Road safety audit response report

| Report title: | RSA Stage 1 – Blackmoorfoot Road |
| Document reference and revision: | Felks Stile Road Junction RSA 1 Rev 1 |

| Project: | RSA Stage 1 – Proposed Development: Blackmoorfoot Road, Huddersfield – (Felks Stile Road Priority Junction) |

| Drawing No: | AMA/22224/D/101 - 1.2 | Rev: | P01 |

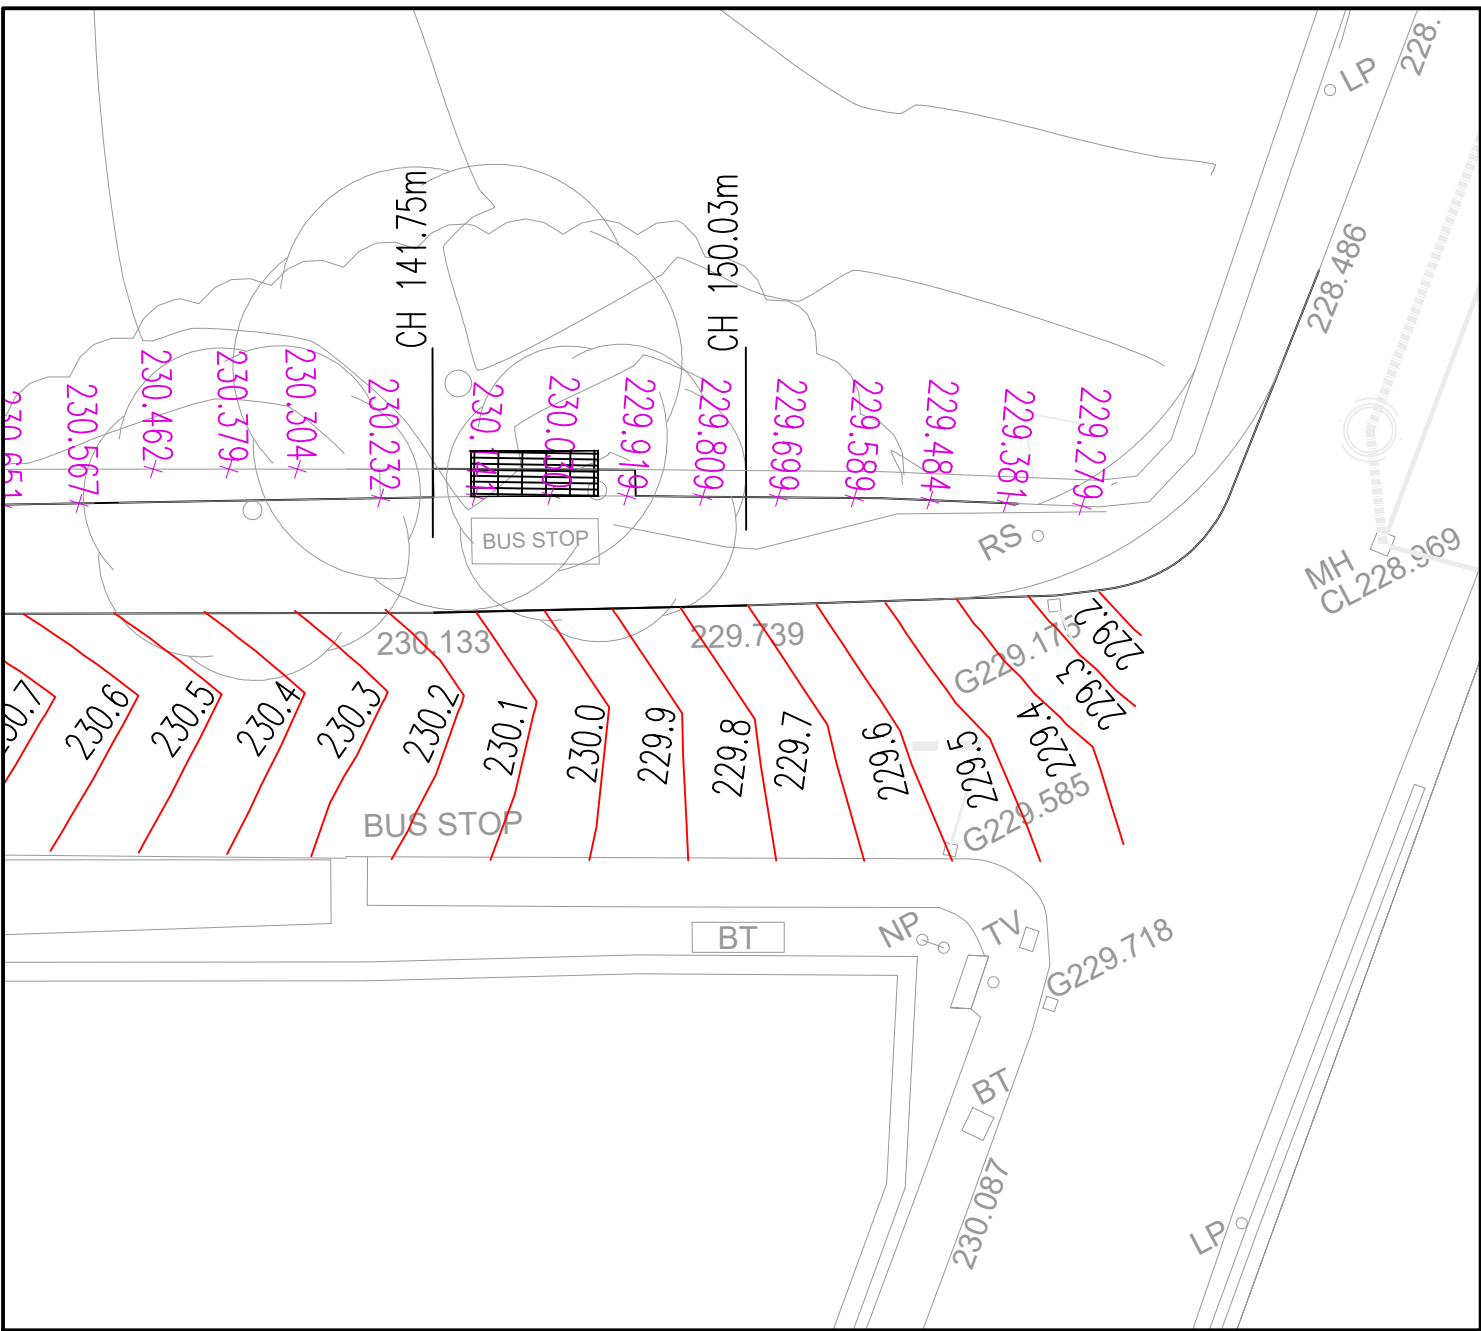
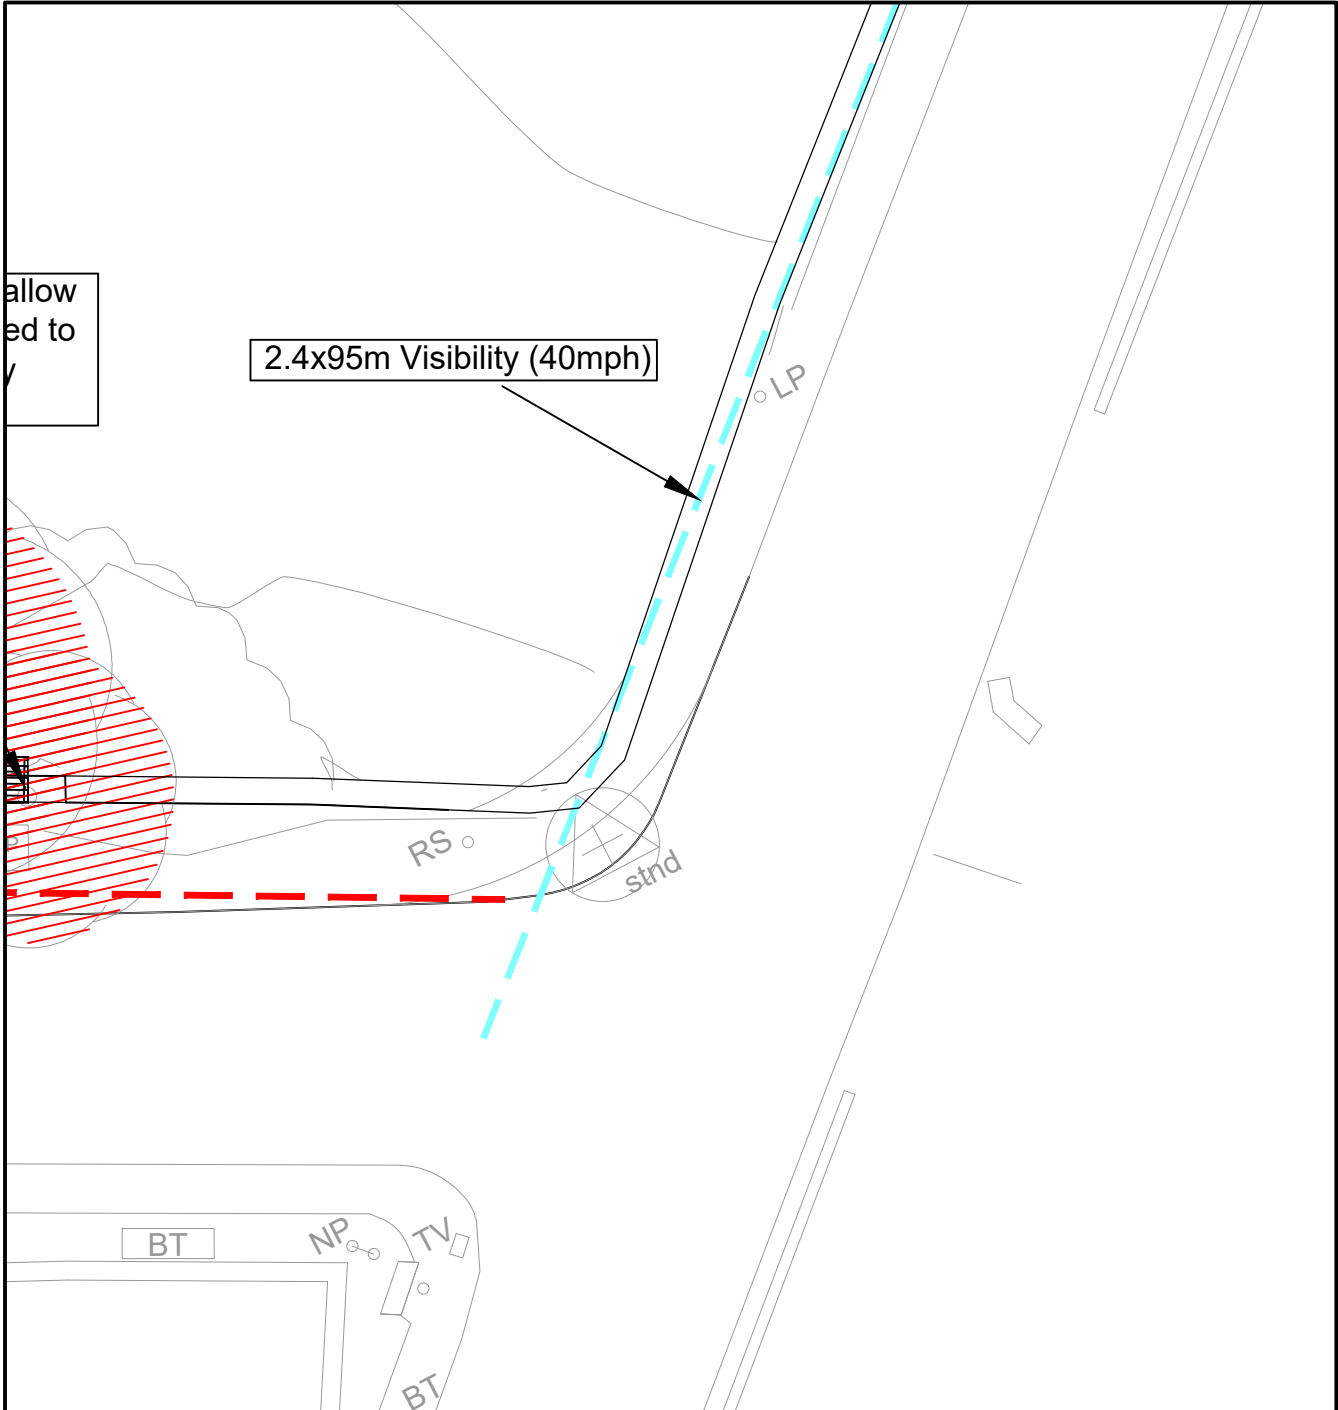
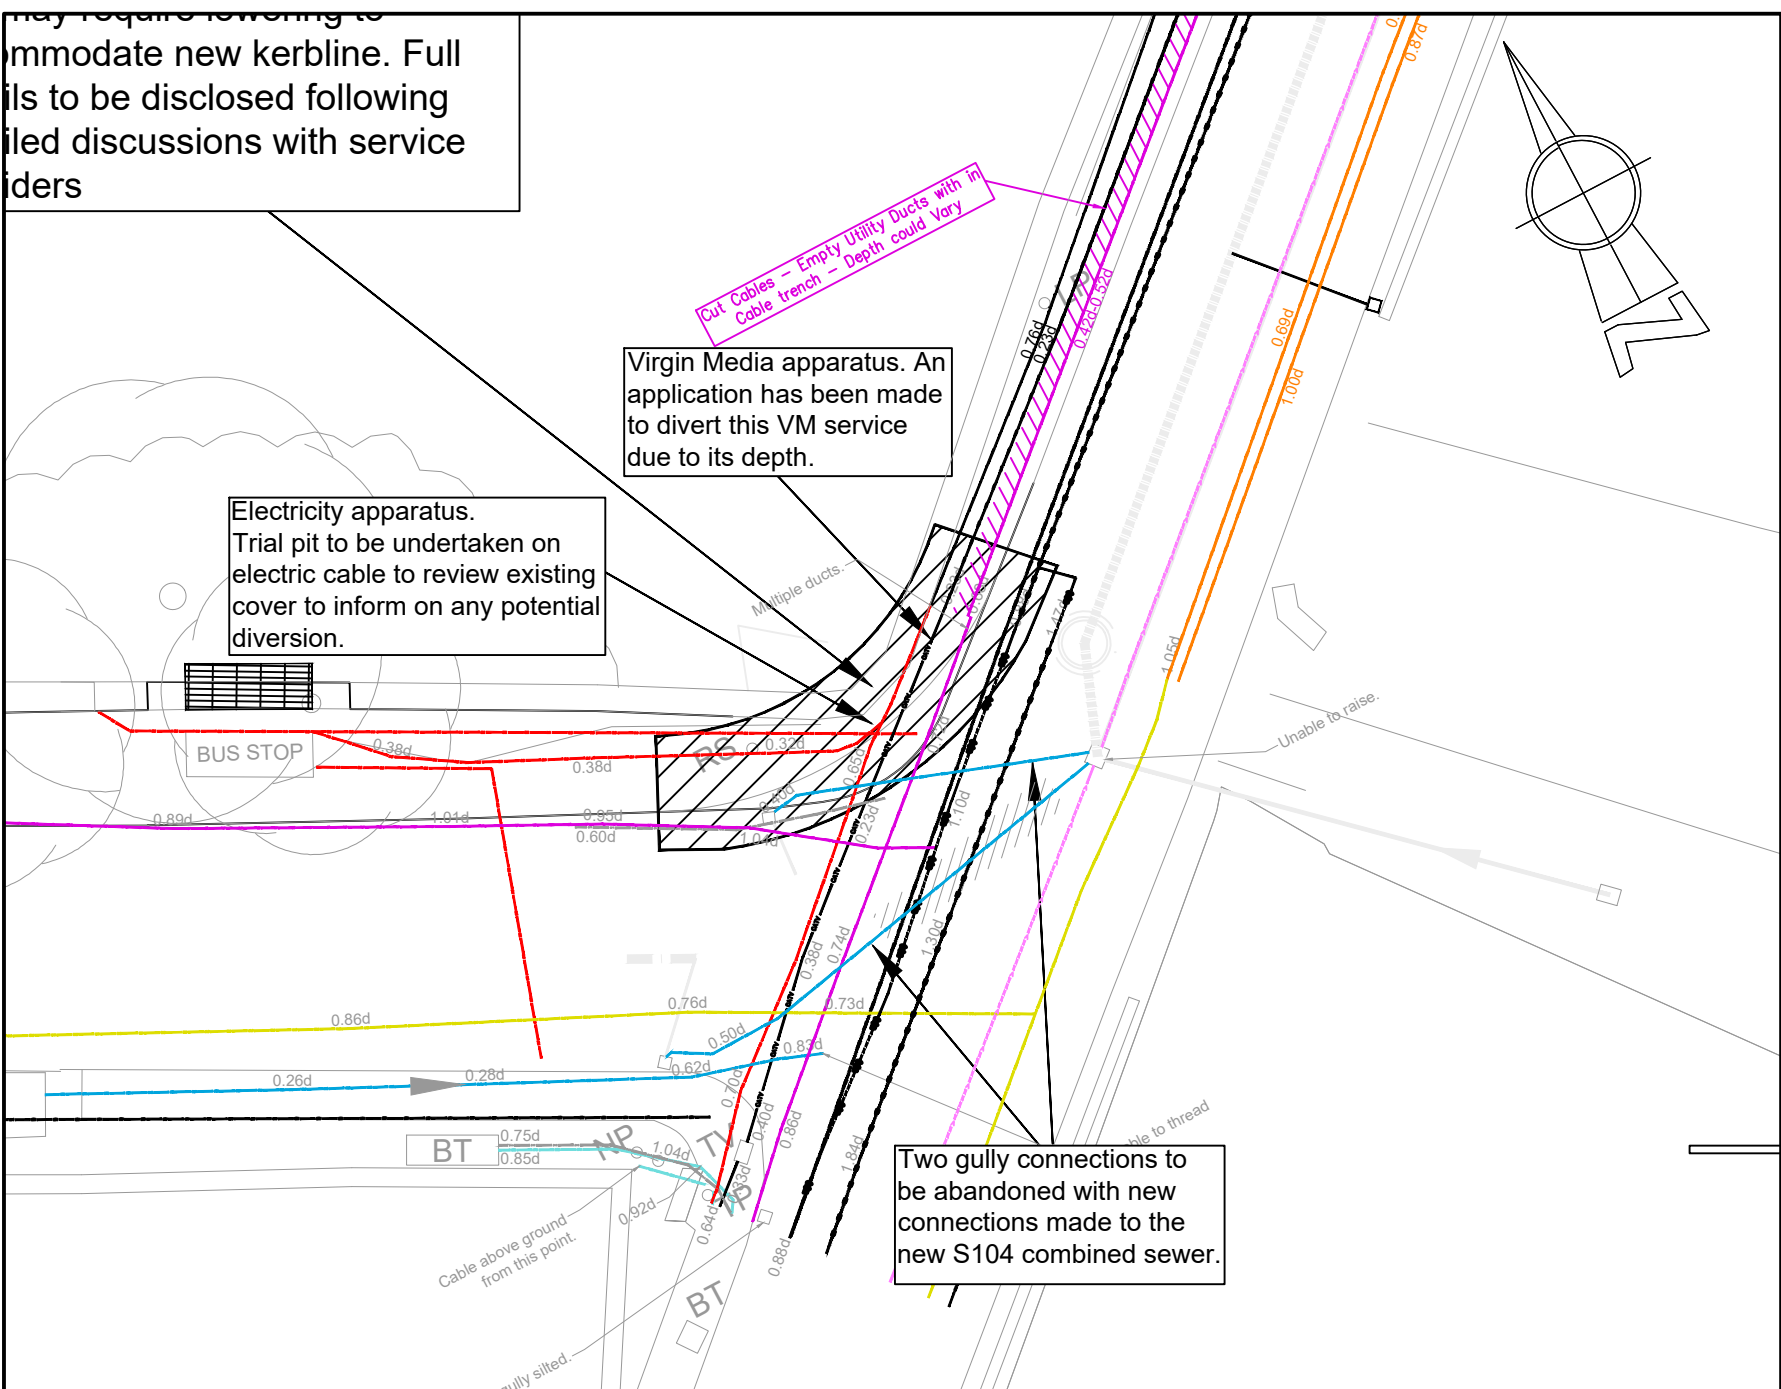
| PROBLEM | | 1-1 |
|---|--|------------|
| Summary: | Details of vehicle tracked movements are not provided on the drawings. Inappropriate carriageway widths and turning radii can result in increased vehicle collisions as well as pedestrian-vehicle collisions. | |
| Details of the swept paths of vehicles, are not provided on the drawings. Inappropriate carriageway widths and junction radii can result in vehicles failing to safely negotiate the new junction arrangements increasing the risk of vehicle collisions and pedestrian-vehicle collisions. | | |
| Provide swept path movements at the new site access junction. | | |

| RSA PROBLEM | RSA RECOMMENDATION | DESIGN ORGANISATION RESPONSE | OVERSEEING ORGANISATION RESPONSE | AGREED RSA ACTION |
|--|--|---|----------------------------------|-------------------|
| <p>1-1: Access junction Felks Style Road. Details of vehicle tracked movements are not provided on the drawings. Inappropriate carriageway widths and turning radii can result in increased vehicle collisions as well as pedestrian-vehicle collisions. Details of the swept paths of vehicles, are not provided on the drawings. Inappropriate carriageway widths and junction radii can result in vehicles failing to safely negotiate the new junction arrangements increasing the risk of vehicle collisions and pedestrian-vehicle collisions.</p> | <p>Provide swept path movements at the new site access junction.</p> | <p>Details of the swept path analysis are included as part of the AMA Drawing Number: 22224-D-101-1.2, attached at Appendix B.</p> | | |
